Subject: Post Permit Revision 1 - Summary Letter

Project: 6221 83rd Pl, Mercer Island, WA 98040  
MI Project # 2207-110

**A0.1**

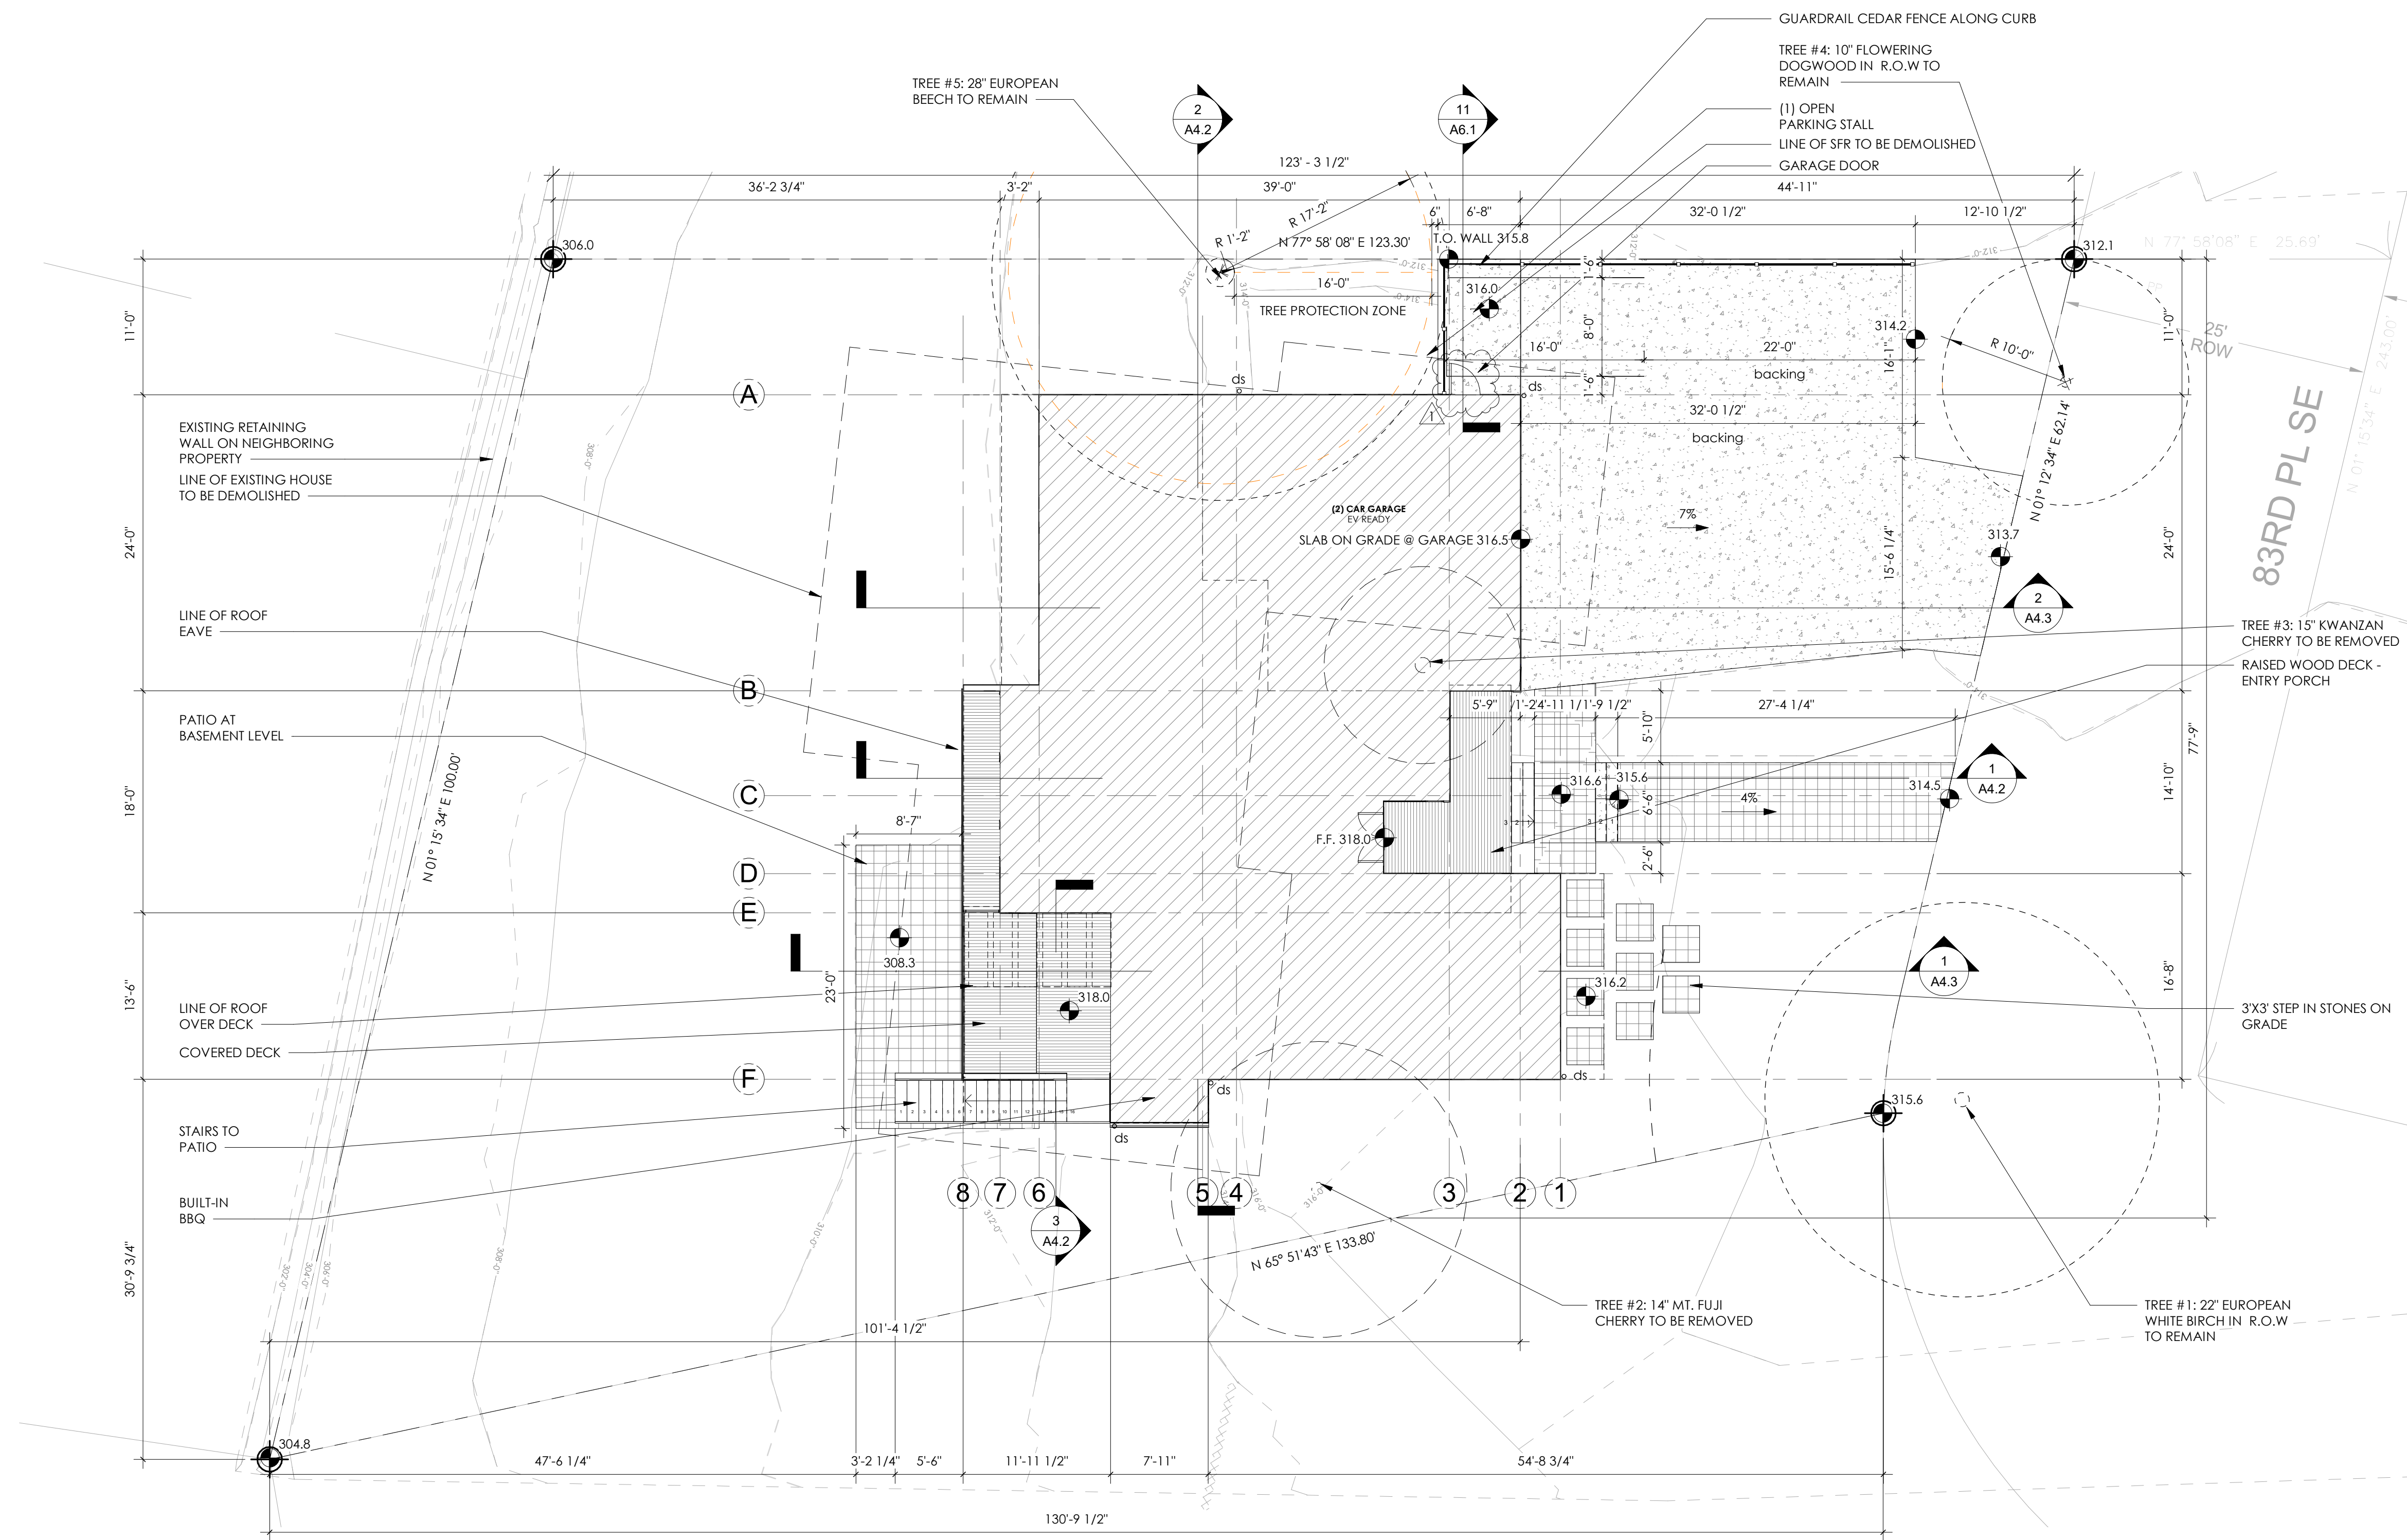
- A0.1 – Site Plan – Exterior door to garage added on north façade.
- A0.2 – FAR Diagrams – Level 2 FAR added.
- A2.1 – Basement Level – Window T has been revised.

**A2.2**

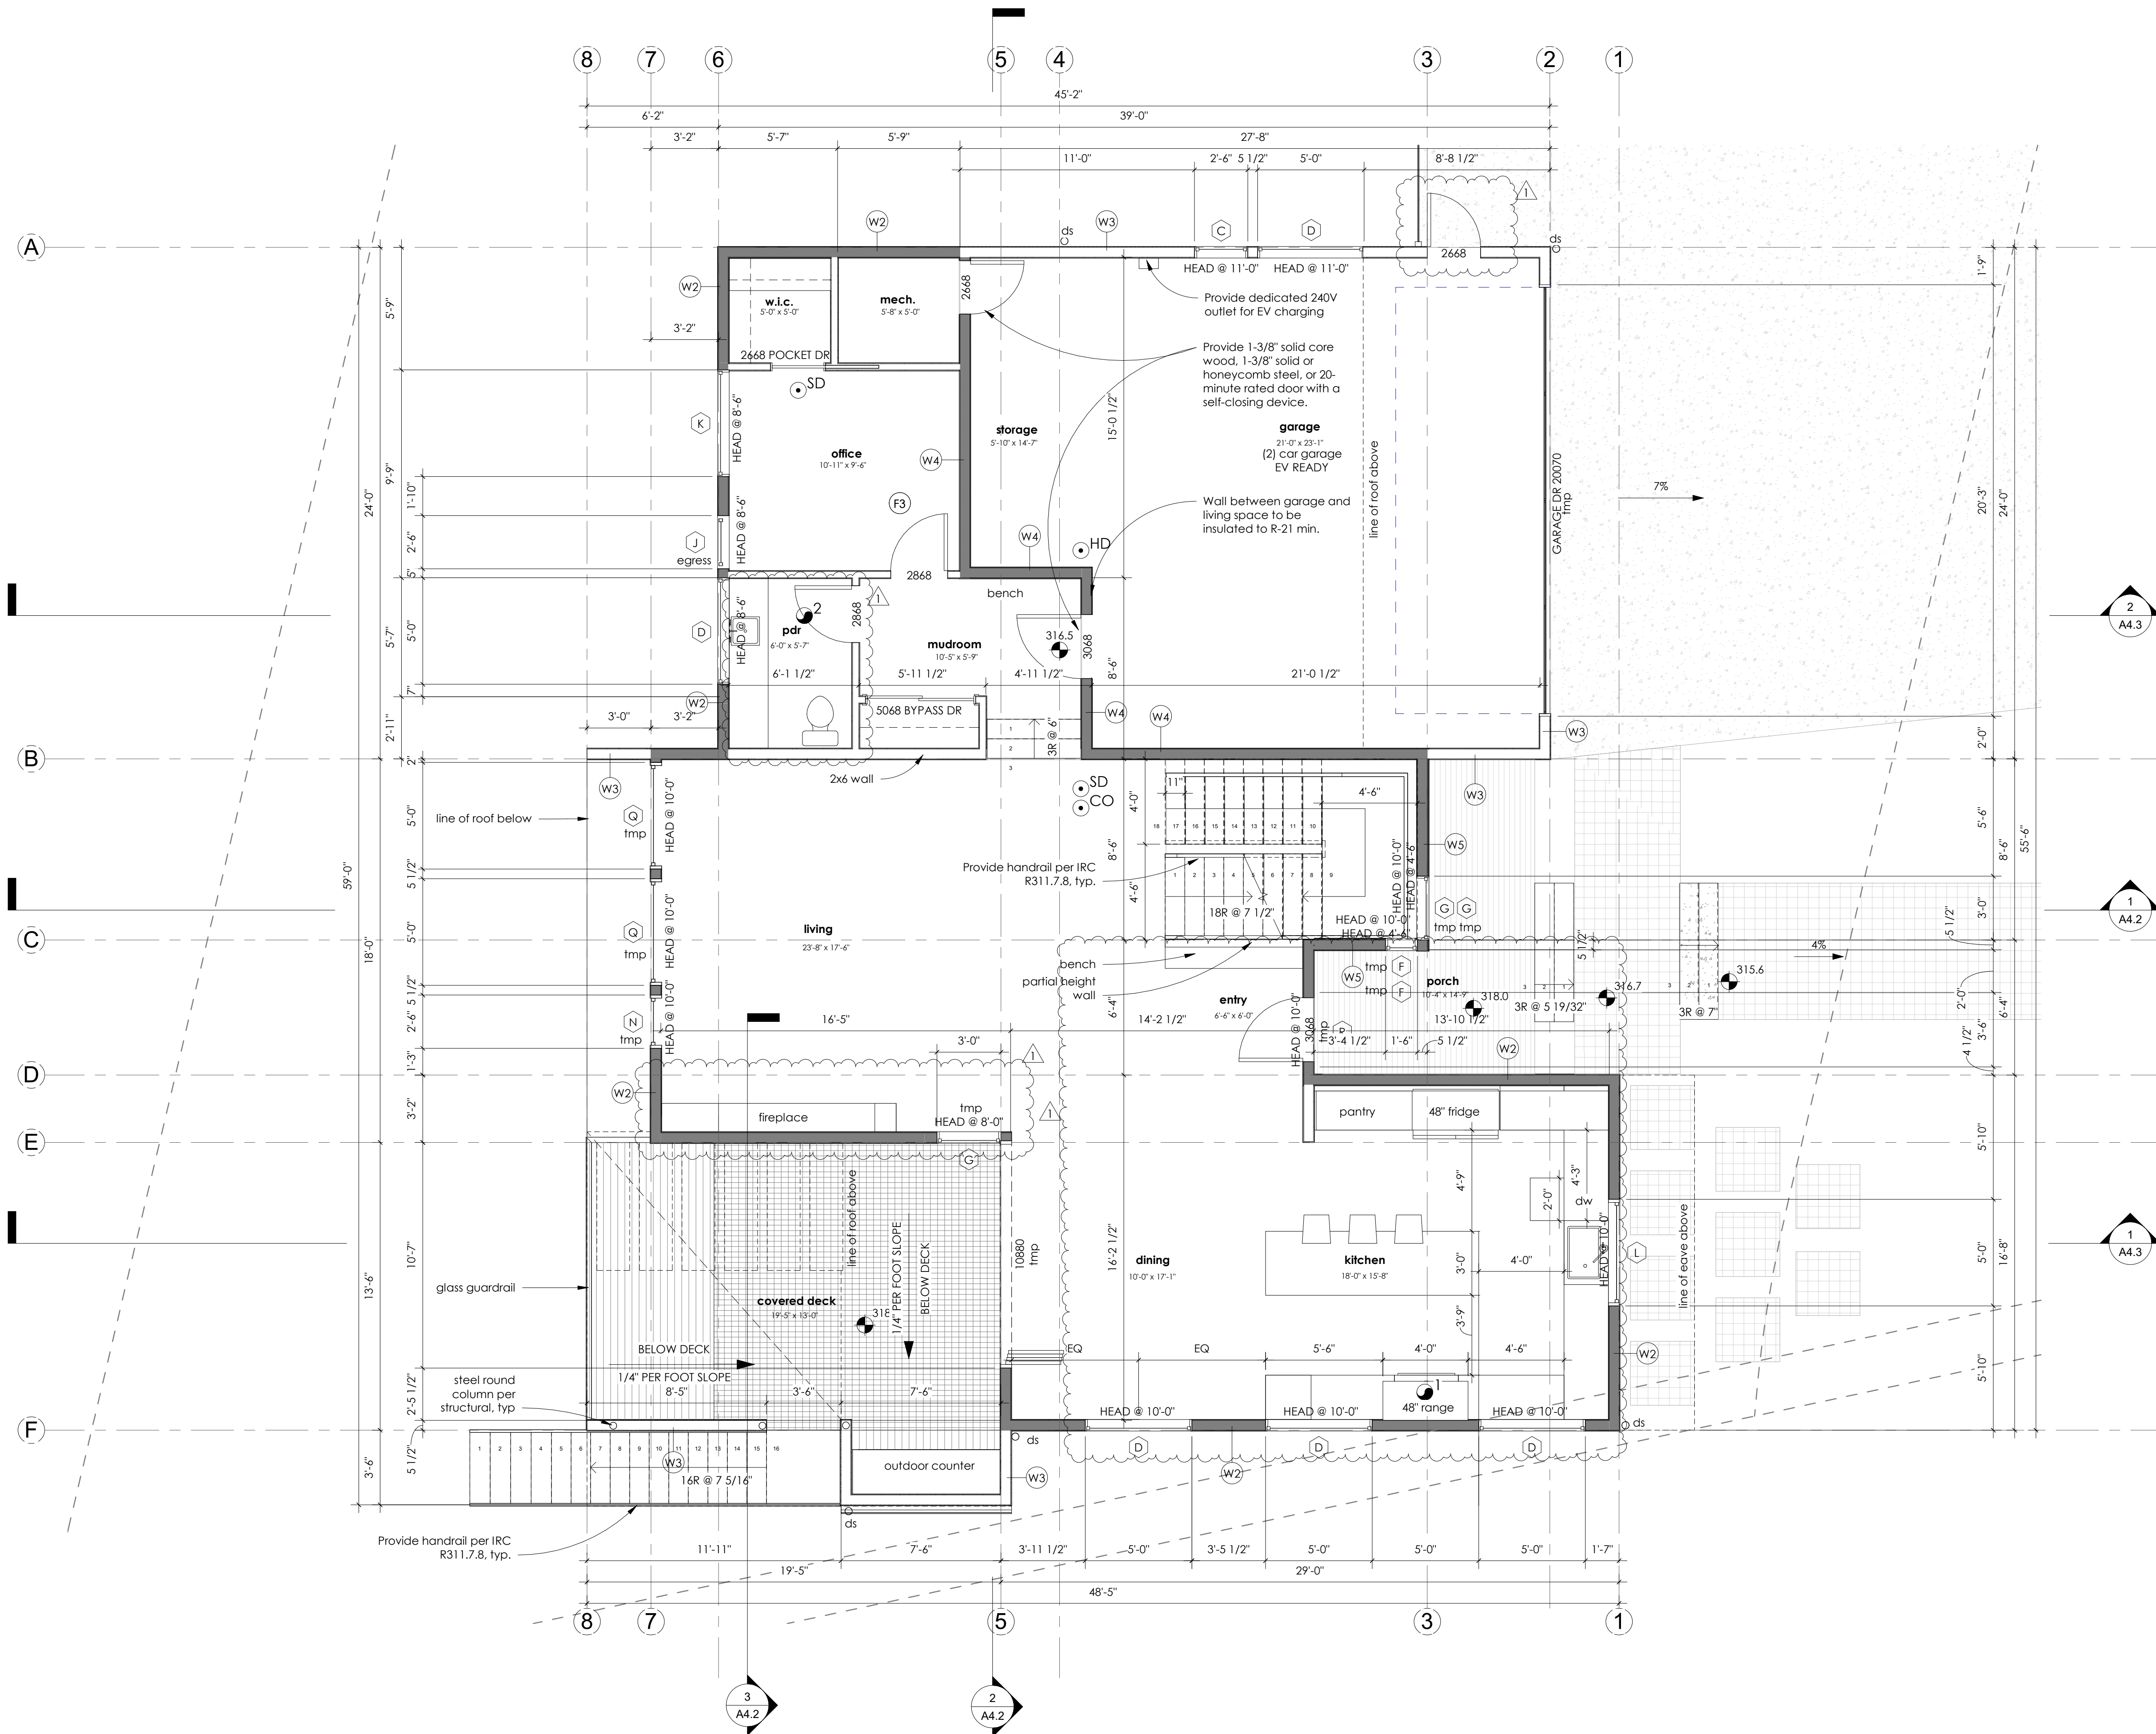
- A2.2 – Level 1 – Garage door, Entry door, powder room, south wall of living room, layout of kitchen and windows.
- A2.3 – Level 2 – Bathroom, Laundry, Master Bathroom enlarged, window changes and layout adjustment

**A2.4**

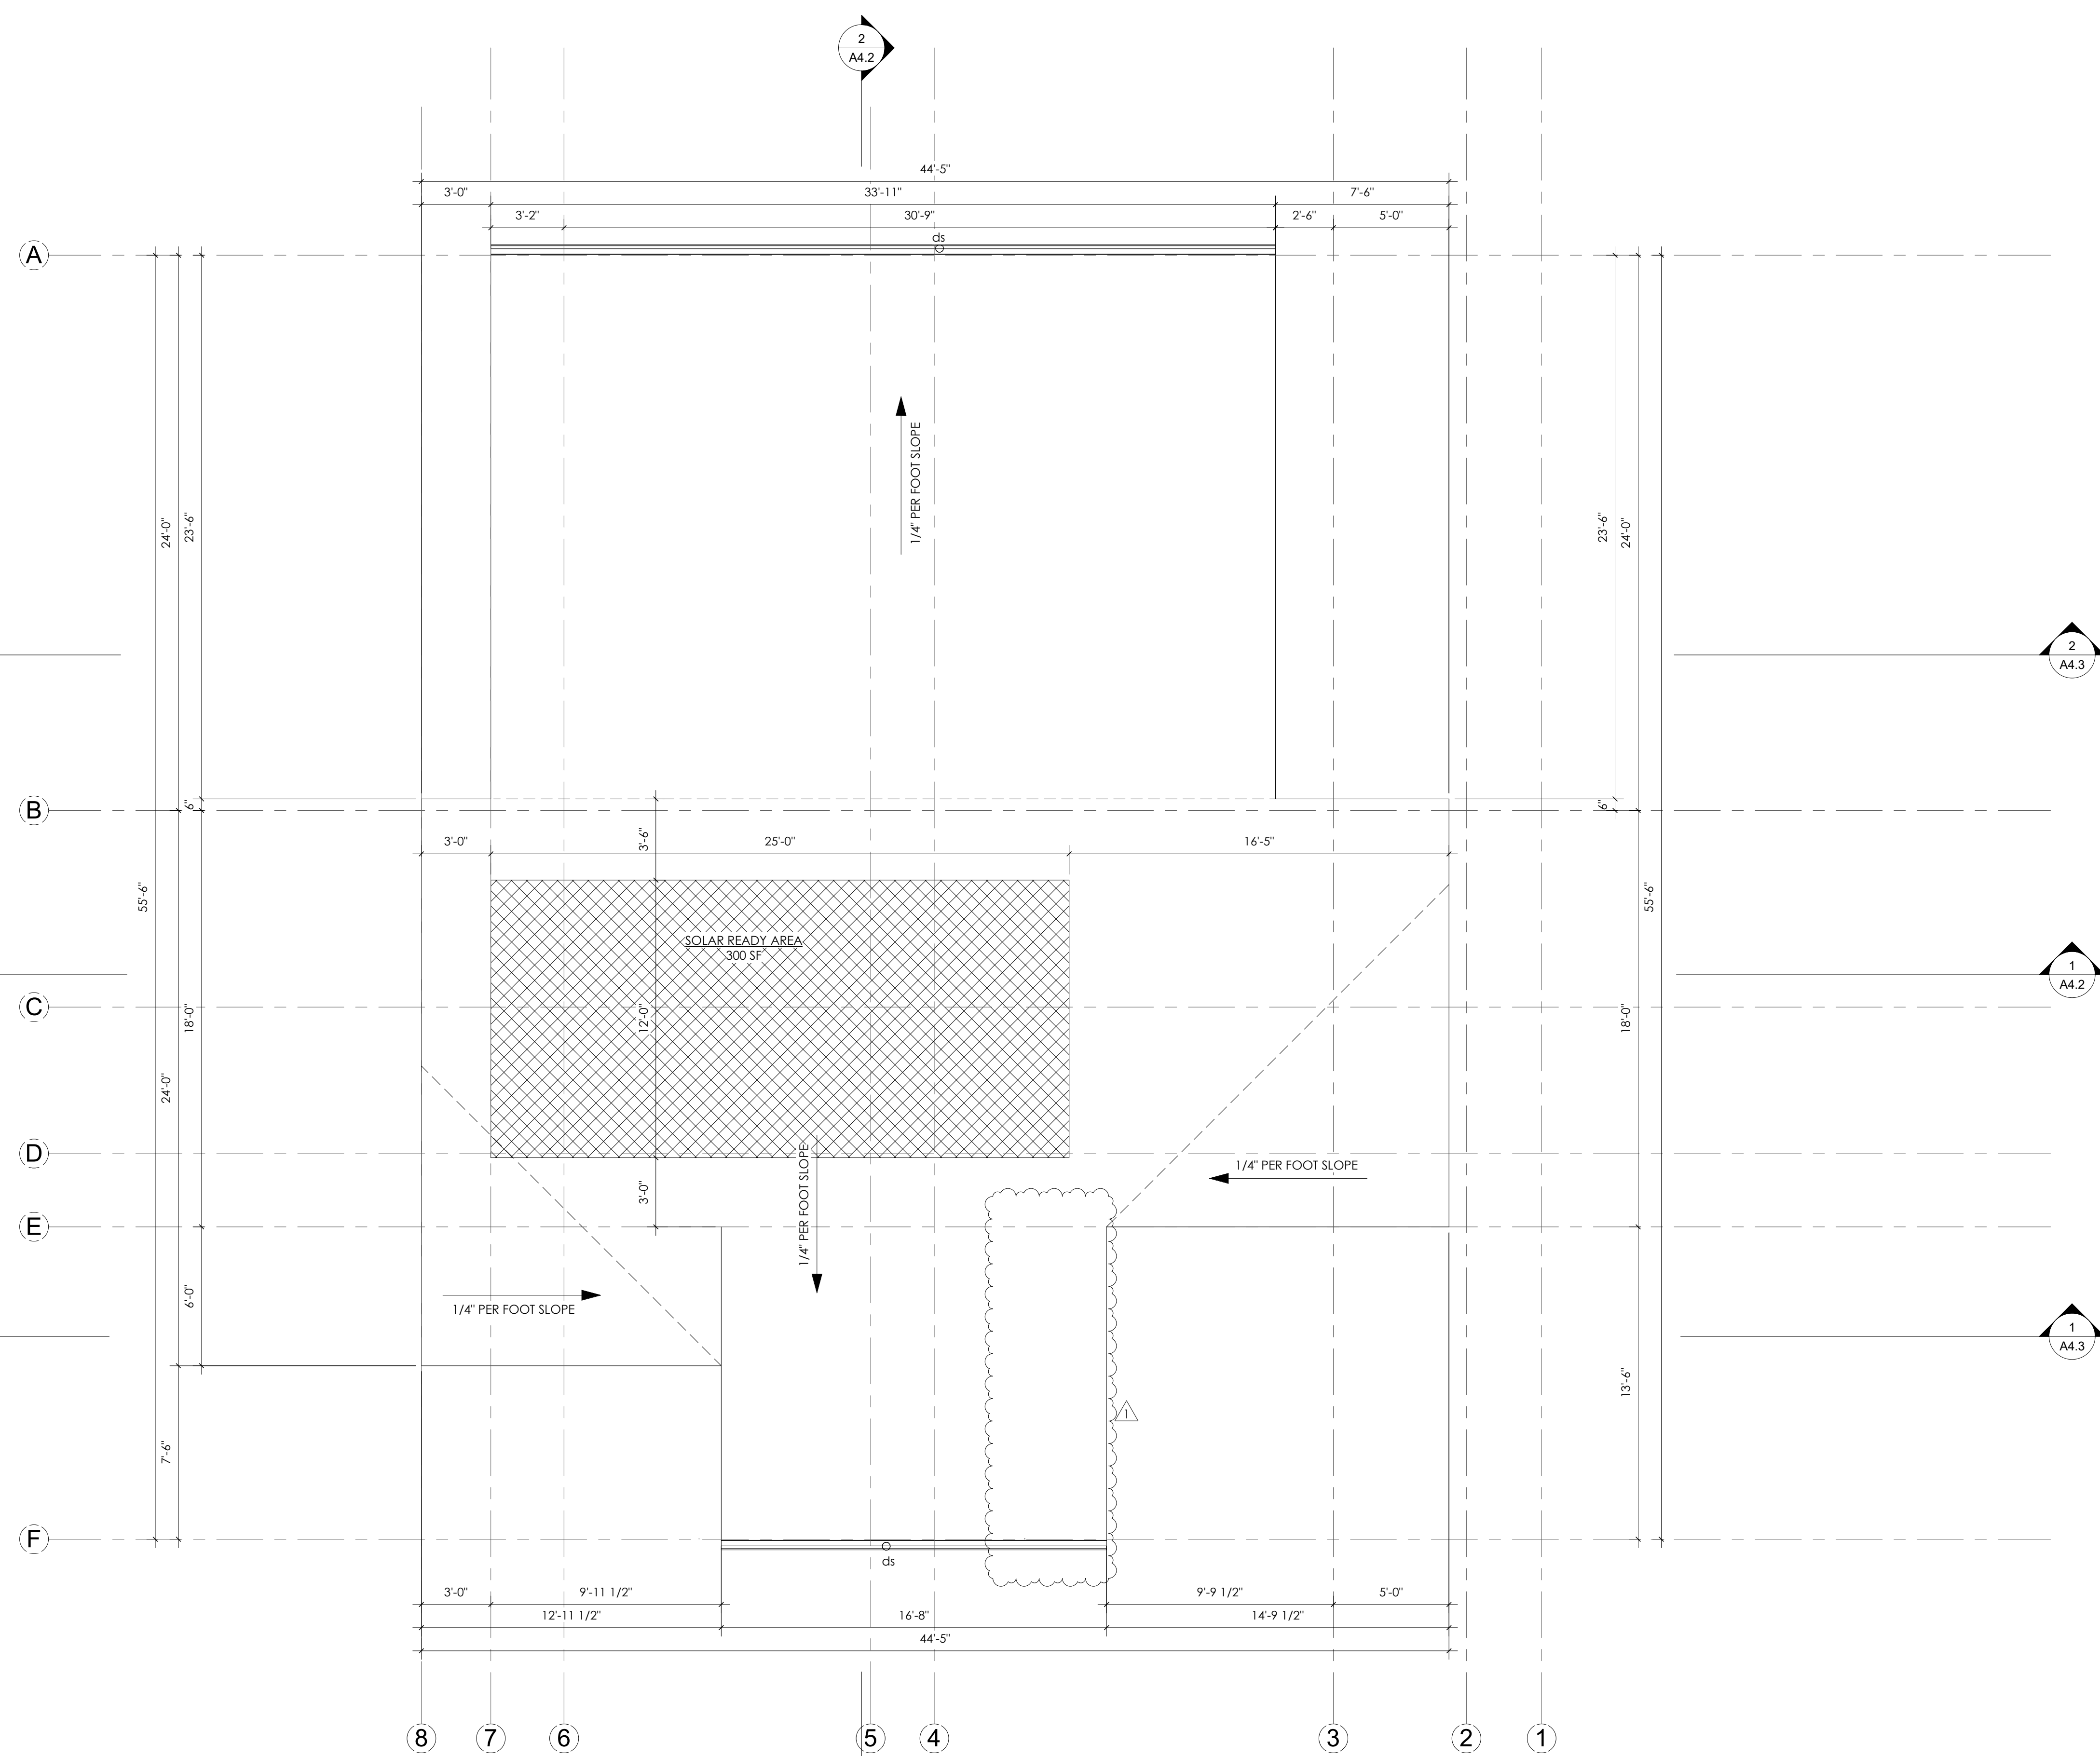
- A2.4 – Roof Level – Revised for enlarged master bathroom
- A3.1 – Elevations – Entry door and windows above, windows at master bathroom
- A3.2 – Elevations – Garage door, window revisions at master bathroom, kitchen, and living room
